SUBJECT: **BRES2503-0037**
BUILDING RESIDENTIAL

Here are the results of all Inspections located at **6745 OLD US 421:**

PROJECT: 30' WIDE
LOCATION: STATE OF NORTH CAROLINA
PROJECT NO.: 325-25-0321
SHEET TITLE: FOUNDATION OPTION 1: CONCRETE SLAB
SHEET NO.: 11-A / 11

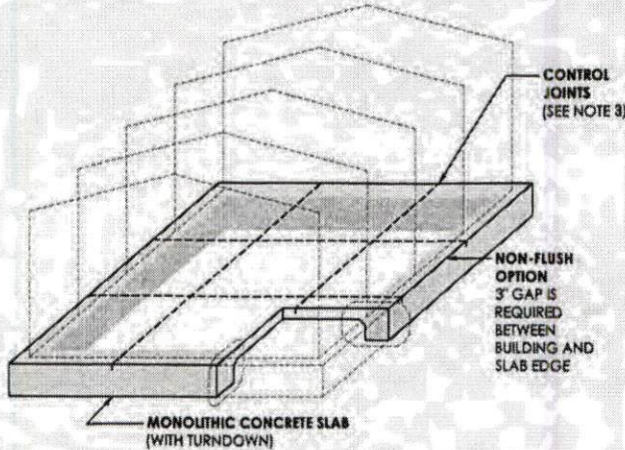
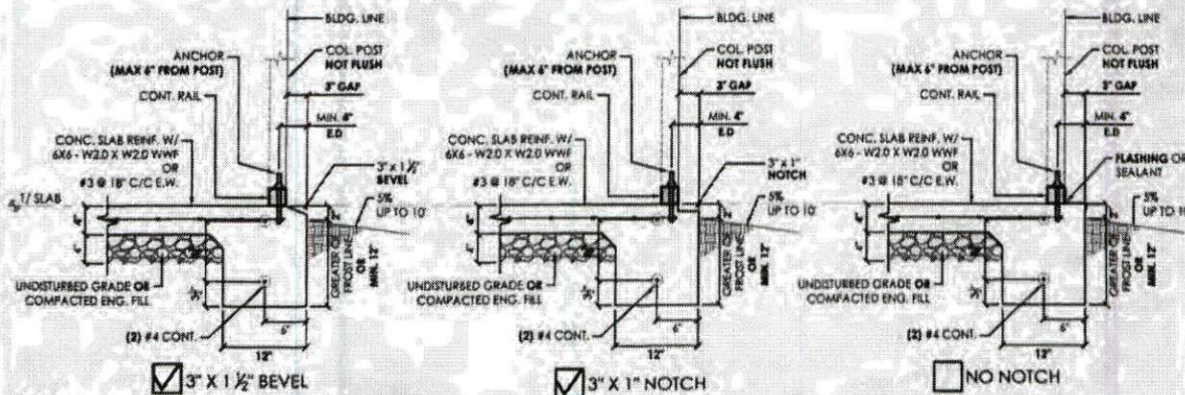
Inspection Type: FINAL**
Scheduled Date/Time: 10/9/2025
Completed Date/Time: 10/9/2025
Inspector: John B Kokoszka
Result: DISAPPROVED
Remarks:
Notes: The building is unlocked and inspector has permission to enter
Need bolts within 6" from every support post per plans
Need bolts within 6" from every support post per plans
